# West Lindsey District Council

Comments on Joint Report on Interrelationships between Nationally Significant Infrastructure Projects Version 1

Document Reference: EN010131/8.26 (Gate Burton)

3 October 2023

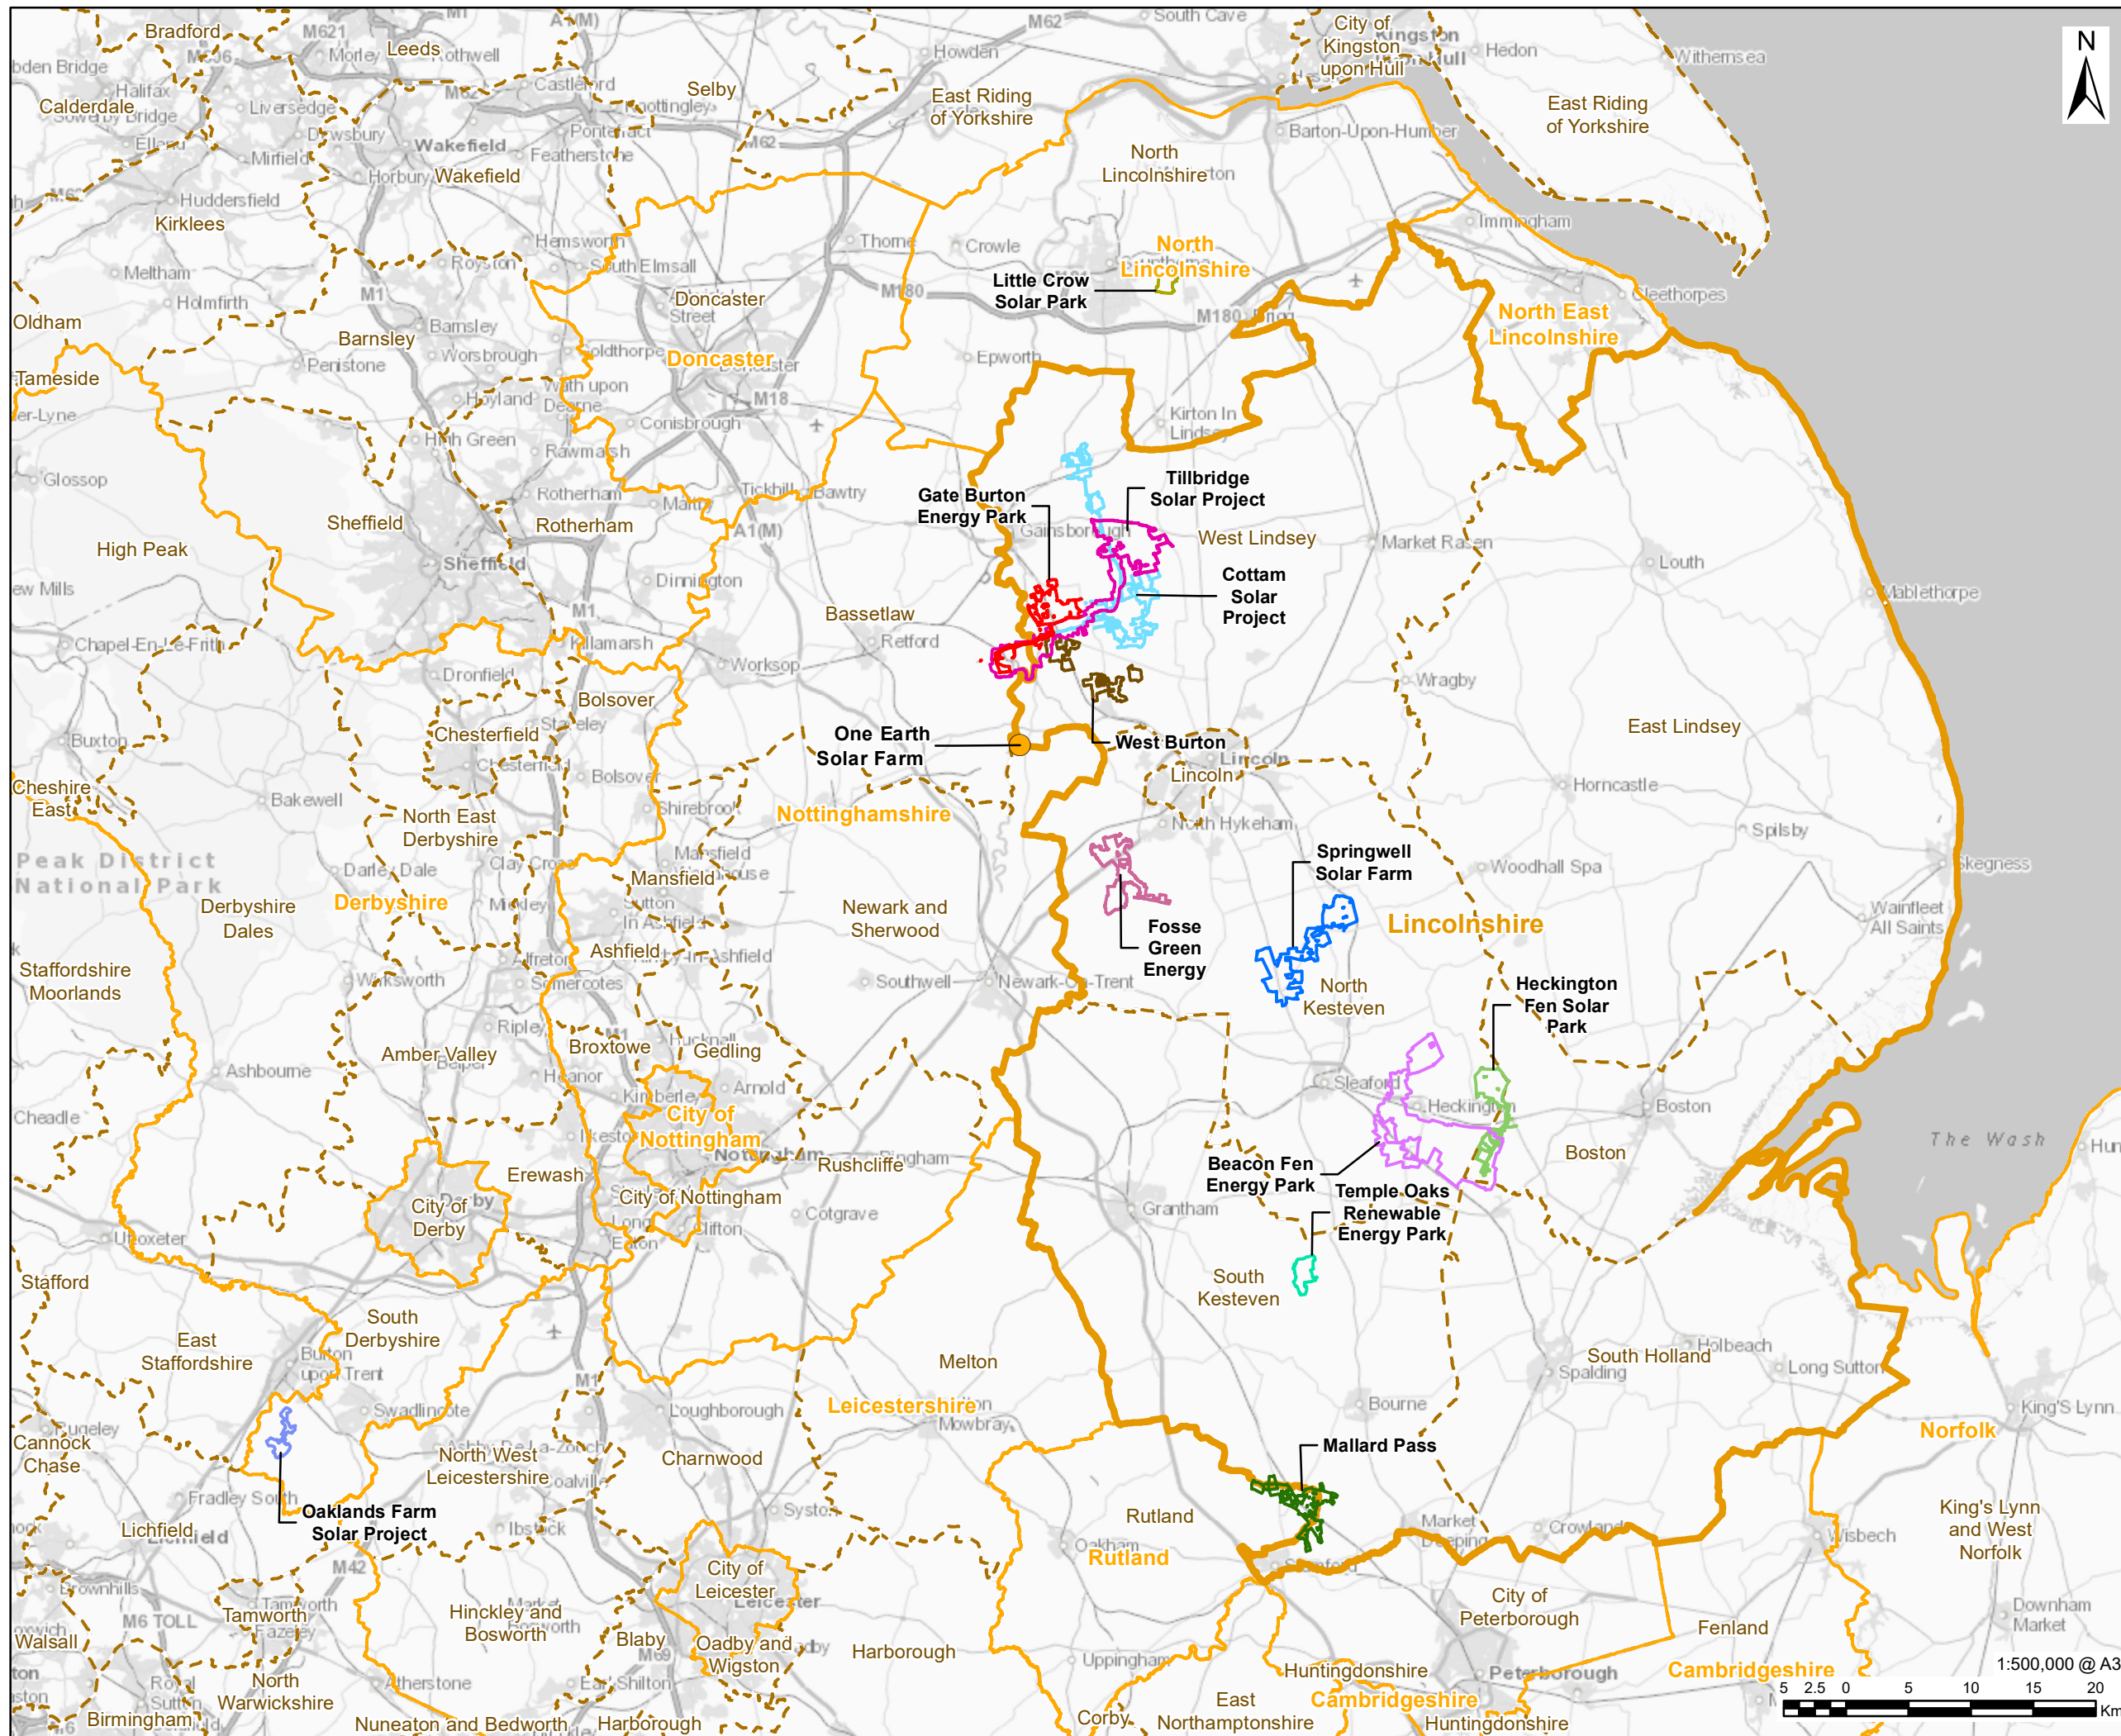
Chapter	Key Points	WLDC Concerns
1. Introduction	1.2.1 and Table 1.2 – List of NSIP Solar Schemes in and around Lincolnshire.	<ul style="list-style-type: none"> <li>It is unclear why it is decided that there 'no' potential for cumulative effects – especially for Fosse Green (7km to West Burton scheme). Rationale is provided for One Earth Solar Farm which is nearby, and makes sense for schemes further away or already constructed to be scoped out, but no detail ruling out Fosse Green. WLDC is unclear as to how a definitive conclusion that there are 'no' cumulative impacts has been reached.</li> <li>This table is labelled as Table 1.4 but referred to in the text as Table 1.2 and is the second table in the chapter. This typo should be amended to avoid confusion.</li> </ul>

1.2.2. – Table 1.3 below provides details of the distances (and direction) between the solar arrays for the Cottam, West Burton, Tillbridge and Gate Burton schemes. The distance between solar arrays is measured at the nearest point to the other relevant scheme.	<ul style="list-style-type: none"> <li>There appears to be two tables labelled Table 1.3. This typo should be amended to avoid confusion.</li> </ul>
